PLANNING CONSULTATION RESPONSE

Application No	2025/1062
Proposal	Demolition of existing domestic garage and formation of new driveway/parking, and outline permission for the erection of 4 houses within the residential garden
Address	Land adjacent to 1A West Street, Worsbrough Bridge, Barnsley, S70 5PG
Date of Consultation Reply	19/03/2026
Consultee	Claire Wilson, Planning Ecologist

Consultation Assessment and Justification

SITE PLAN
SCALE 1:250

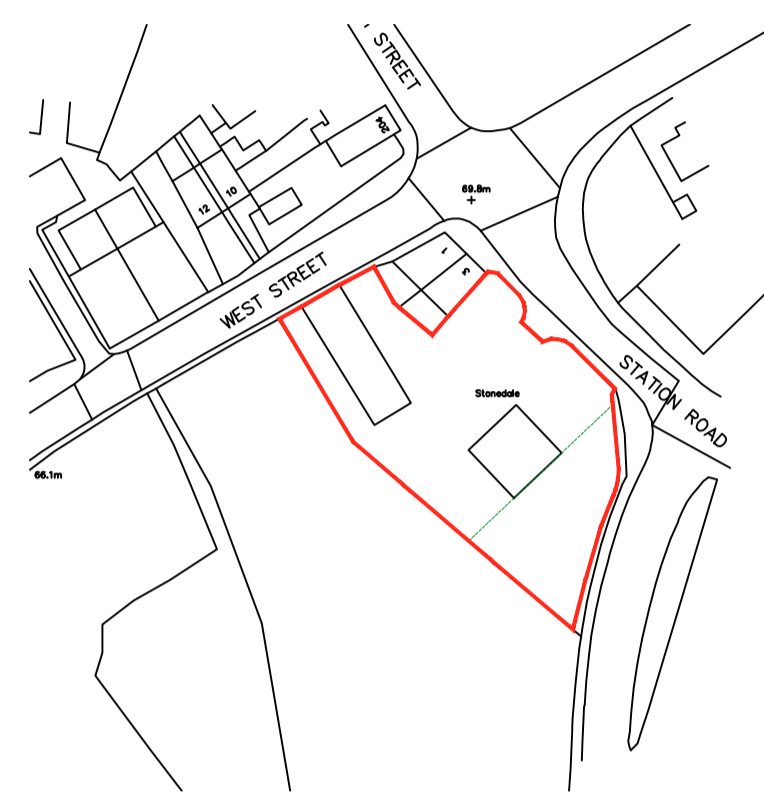
Areas currently mapped as parking on the Location and Site Plans have been excluded from the BNG assessment (see screenshot below). However, aerial imagery confirms that grassland is present within these areas and it is assumed this grassland will be lost to accommodate the parking. In addition, further sections of grassland and an existing building to the north fall within the red line boundary but have not been included within either the BNG assessment or the PEA. I seek clarification on this.

The site plans indicate that each of the four proposed dwellings will have relatively small garden areas, with a larger area of modified grassland situated outside the gardens, but within the red line boundary. Could the applicant please confirm whether the modified grassland will lie outside the boundaries of the residential curtilages? If this area is to remain outside the curtilages, clarification is required regarding its long-term management arrangements. Specifically:

- Who will be responsible for managing and maintaining the grassland for the required 30-year period?
- What measures will be put in place to ensure residents do not encroach into, alter, or domesticate this grassland area?

If the modified grassland falls within the curtilage of the dwellings then it should be mapped as vegetated/unvegetated garden, as per metric guidance.
